**Surrey Heath Borough Council Deadline 7 Submission**

**Written Response to the The Examining Authority's written questions and requests for information (ExQ2) and submissions by Esso Petroleum Company Limited**

**Esso Petroleum Company Limited Southampton to London Pipeline Project Application for a Development Consent Order**

**Project reference no. EN070005**

Drawing number: **B2325300-JAC-000-ENV-DRG-111156**

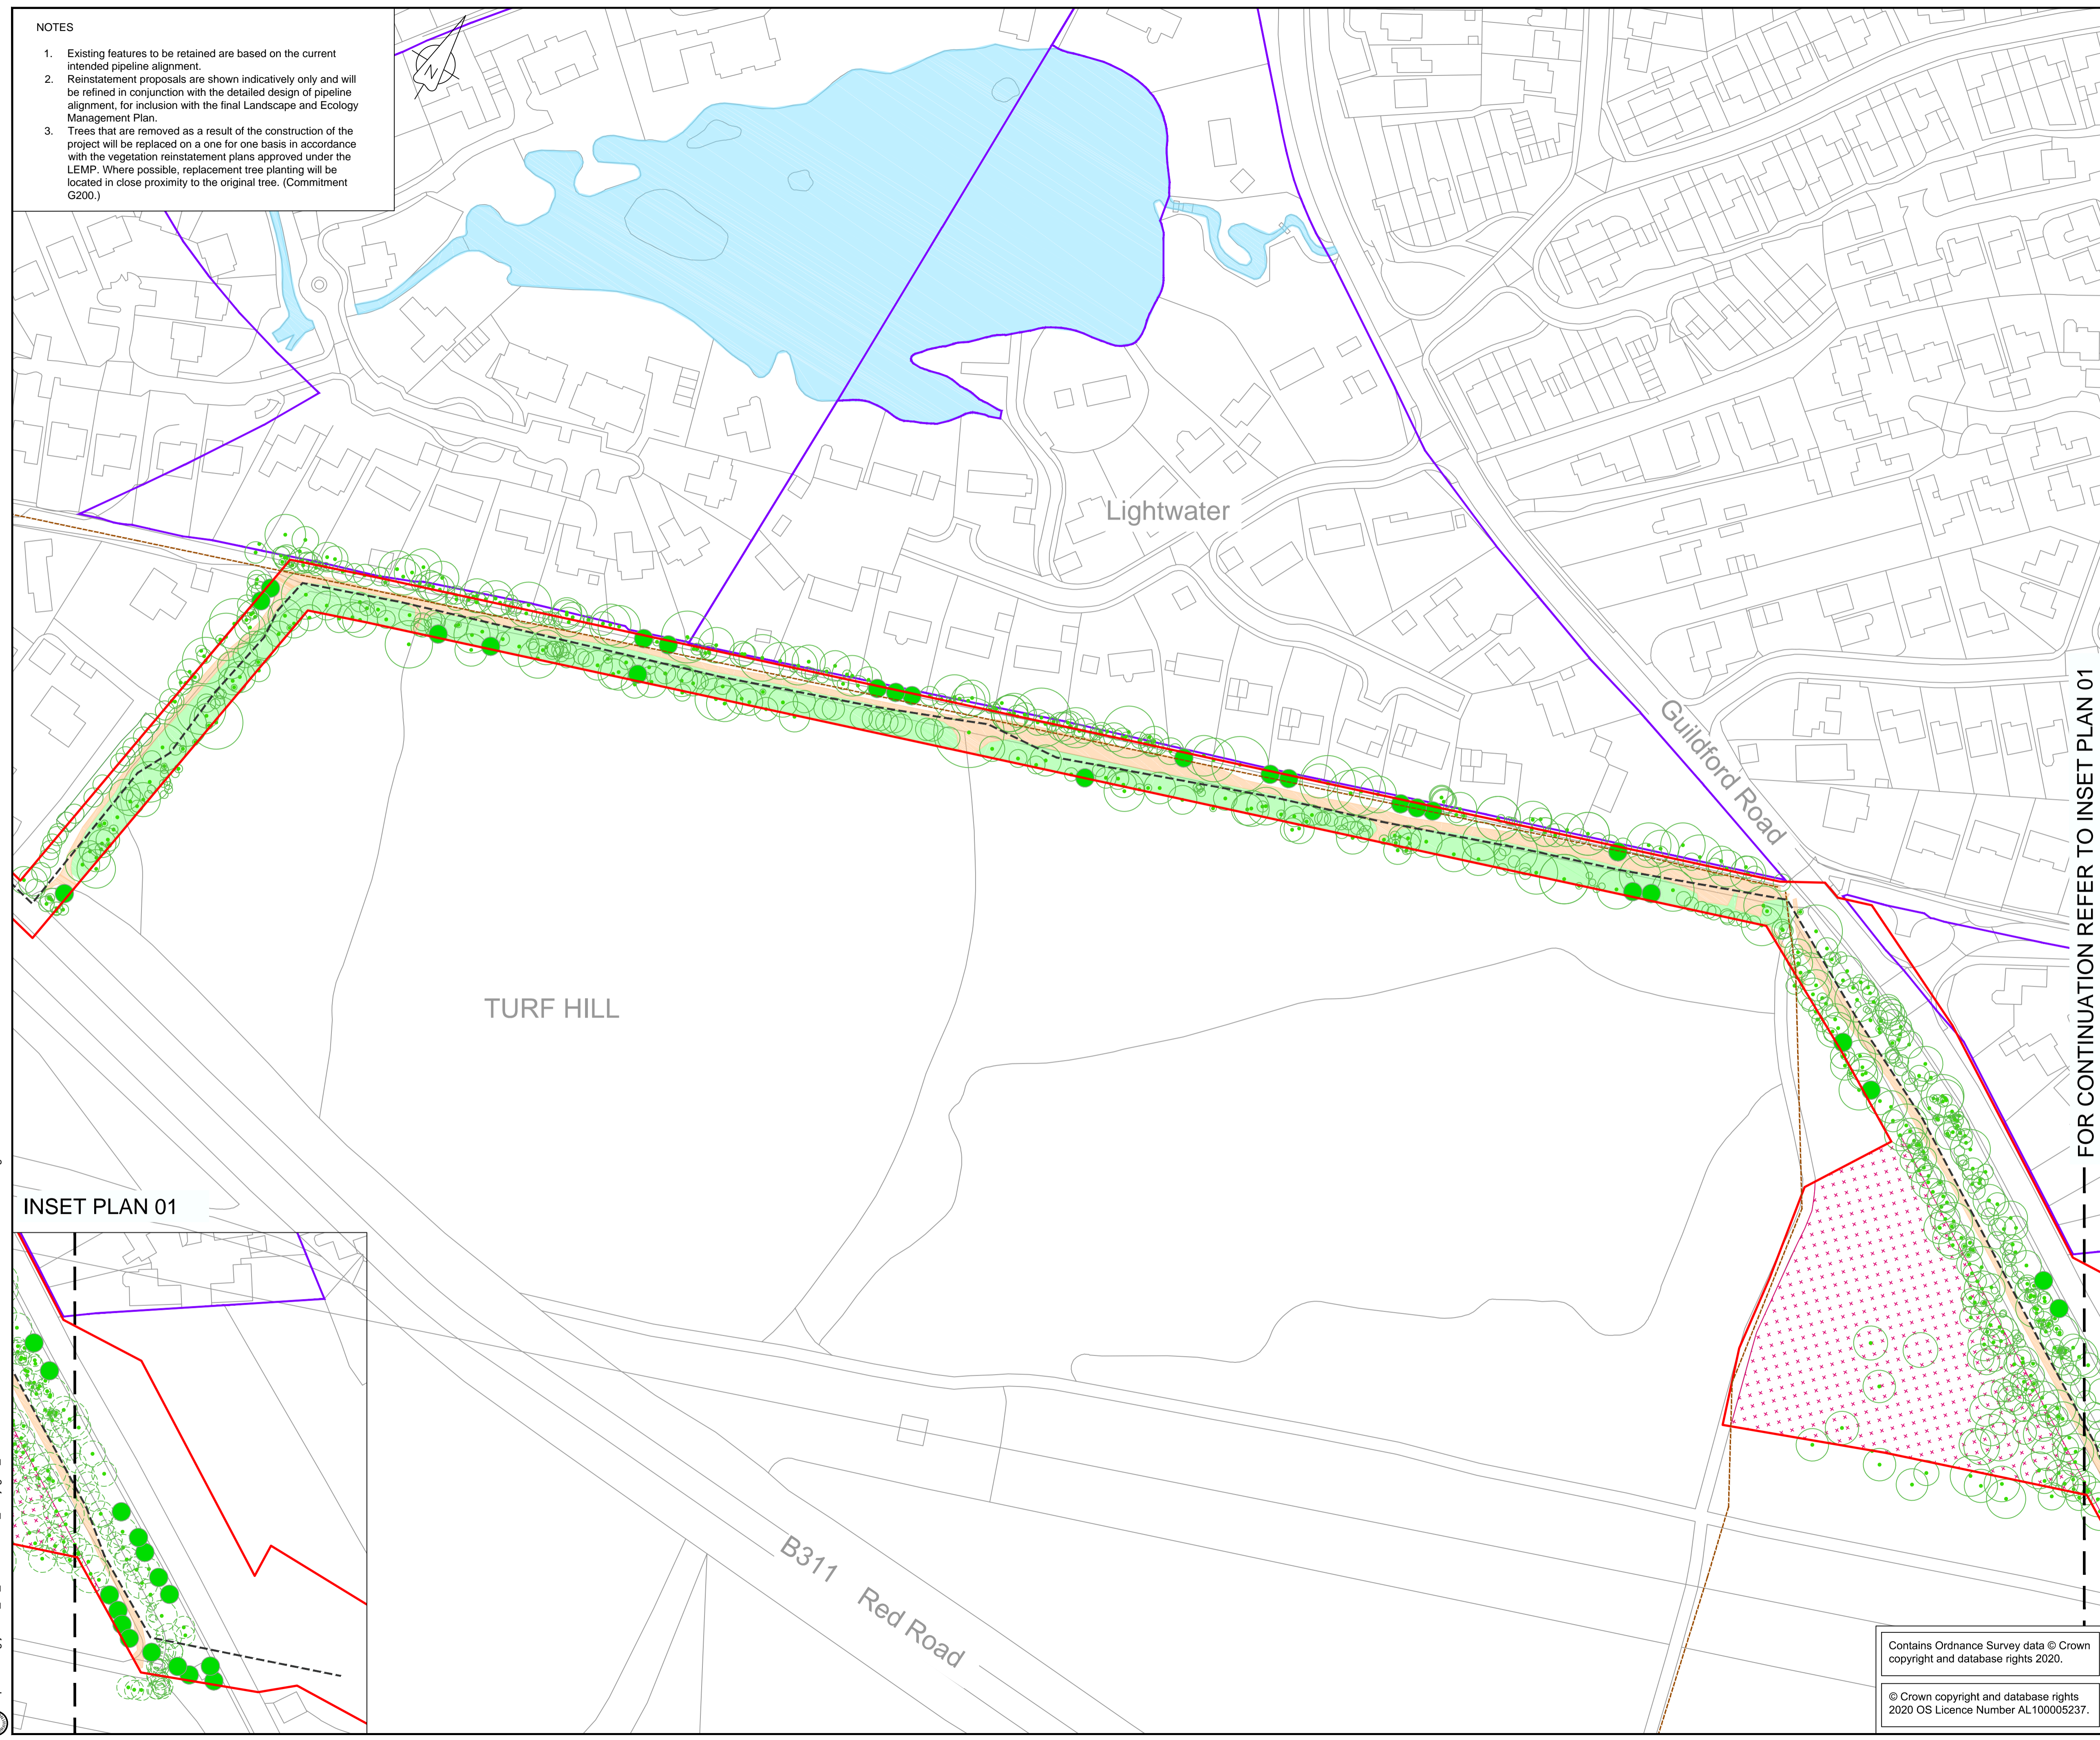
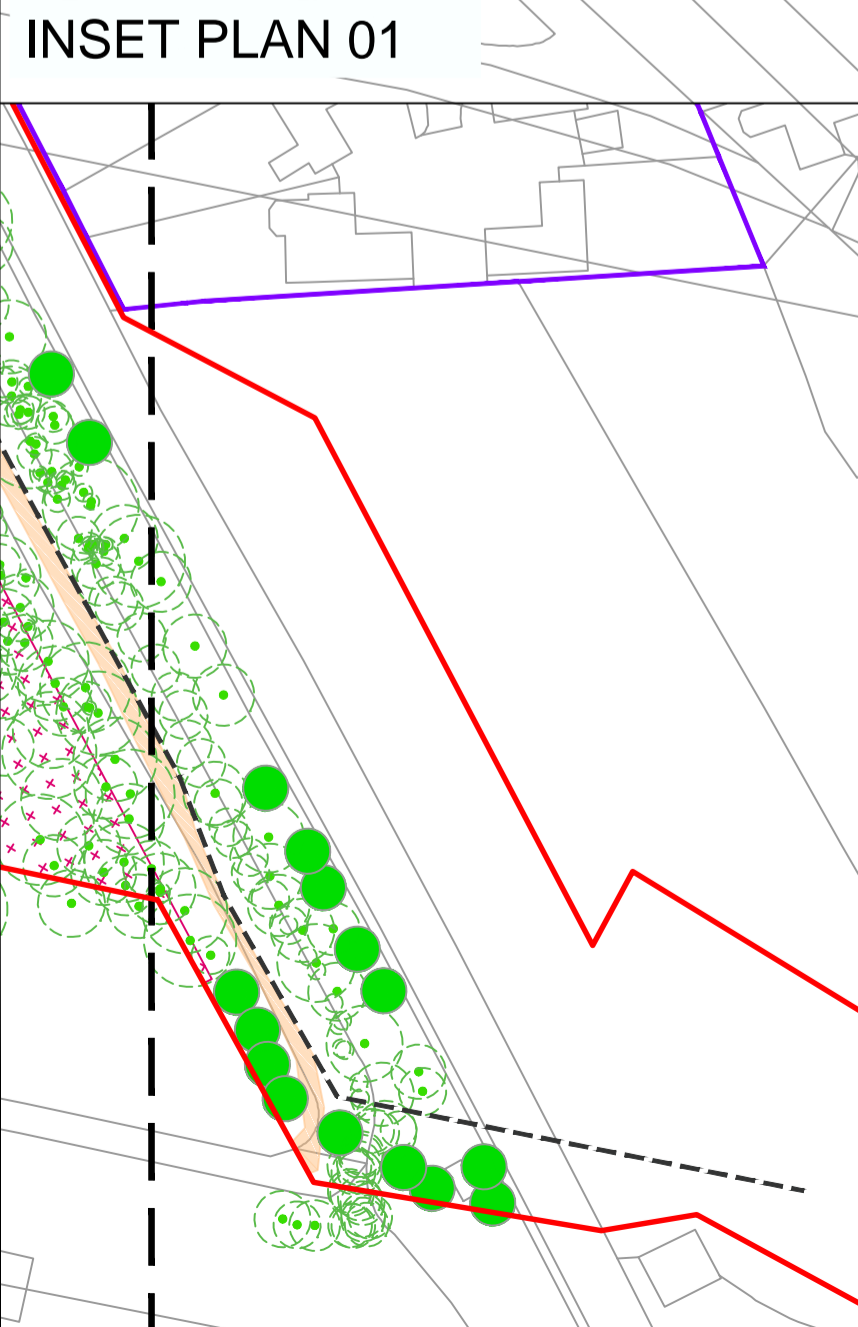
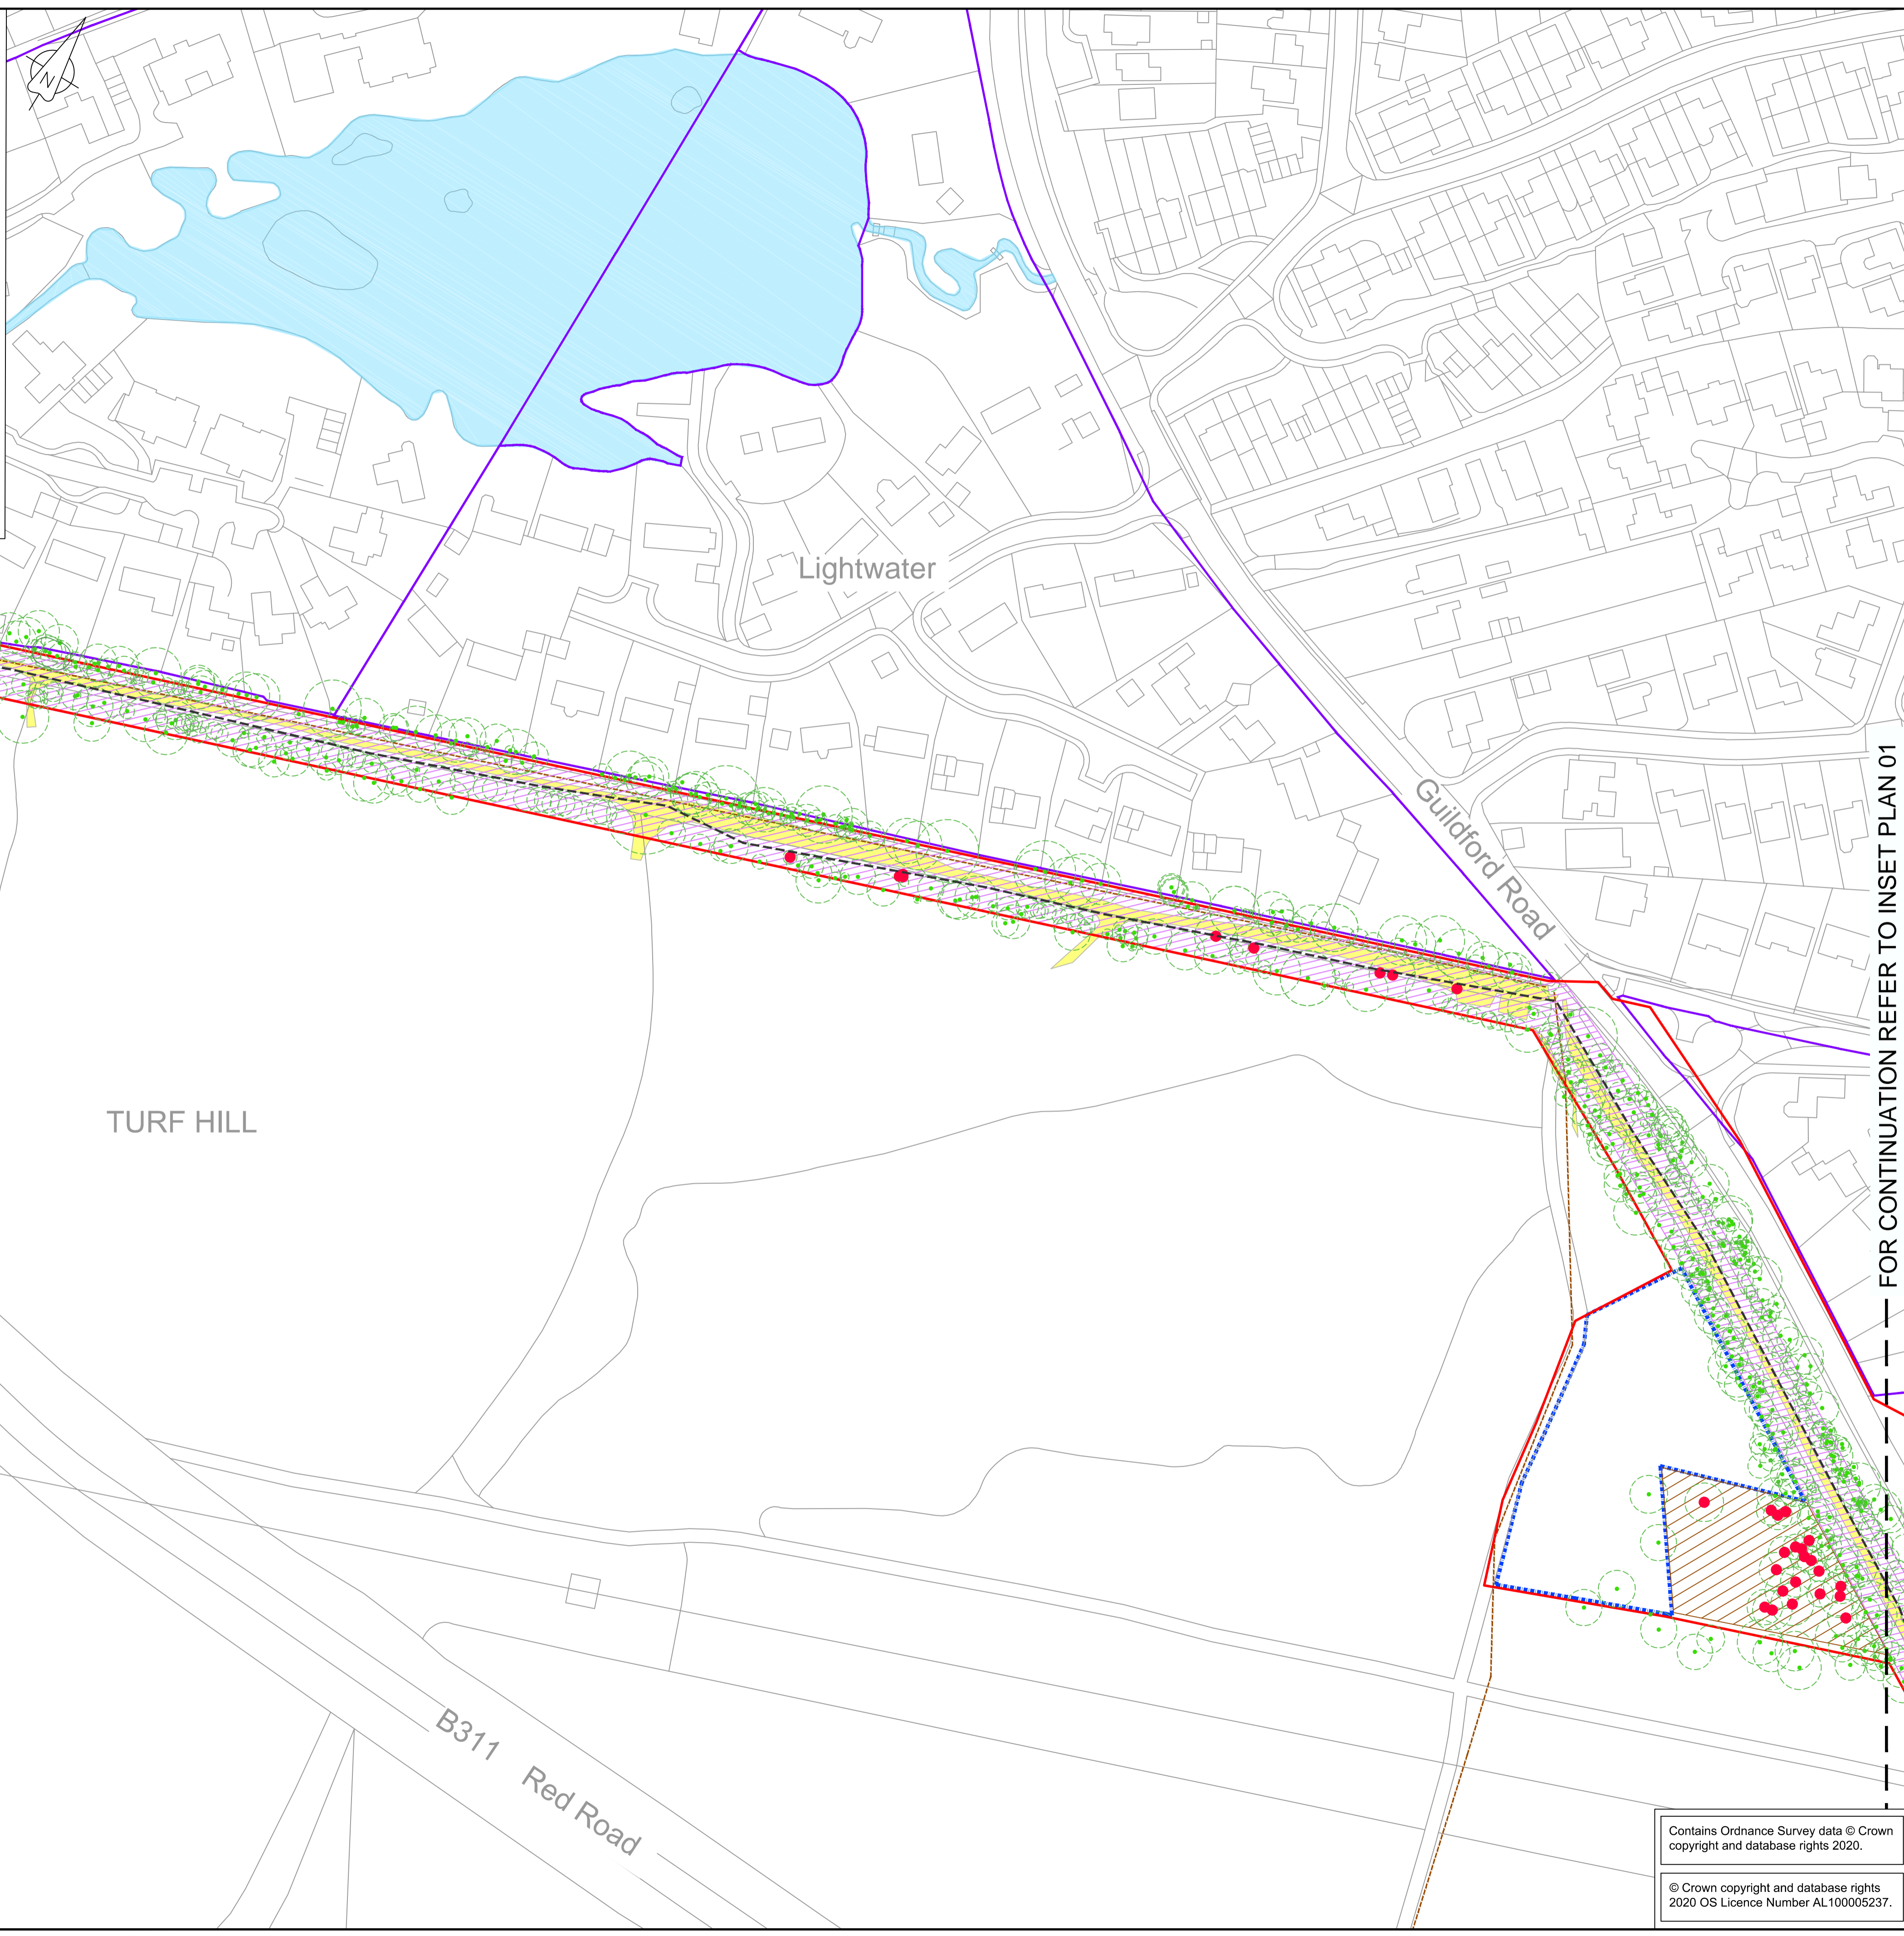
With regard to paragraph 3.2.2 the proposed site compound is shown to be located in a relatively high density area of trees consisting of roughly 50/50 Silver Birch of a mainly early to mature age class, and Scots Pine of a more mature bias. The suggested number of trees to be removed for the access route of 18 self-set Silver birch is considered to be an underestimate and realistically double would be as more

accurate assessment. The compound removal estimate of 21 trees, but none of a mature status, is again considered to be unrealistic and there are at least 10 mature trees with another 25/30 early mature to be removed. Consideration should be given to other options which would require a significantly lower number of less important trees to be removed.

The 'footpath' to which the pipeline is to be located is approximately 6m wide. The information in the applicant's report details a working area of 10 /15m wide and the actual trench a width of 1m and unknown depth. This working area does then include a significantly greater number of trees than shown on their BS5837:2012 drawing and additionally when looking at the intended pipeline location there is a greater impact on supposedly retained trees.

Along the whole pipeline length the intended method of excavation is an 'open cut trench. This will undoubtedly result in unacceptable amounts of root damage and of a root diameter exceeding the B.S. criteria, especially when their RPA calculations from some of the more critical trees do not appear to be correctly represented. Whilst noting the provision at paragraph 3.5.2, which should include reference to an appropriately qualified arboriculturalist, the Council has concerns that this would result in further tree loss to that identified, particularly given ground level variations and other root growth restrictions.

It is considered that, having regard to trees above a stem diameter of 200mm which will be necessary to remove to achieve the pipeline installation, there are in addition to the applicant's assessment of 21 trees, another 30 to be removed. These are of a proximity that even with a none mechanical excavation method, are of such close proximity that roots over 100mm in diameter will be revealed and how these could be retained whilst trying to lay this large pipe would be challenging if not viable. Unless the whole process is carried out under full arboricultural supervision then it is considered that roots would be severed on a frequent basis.
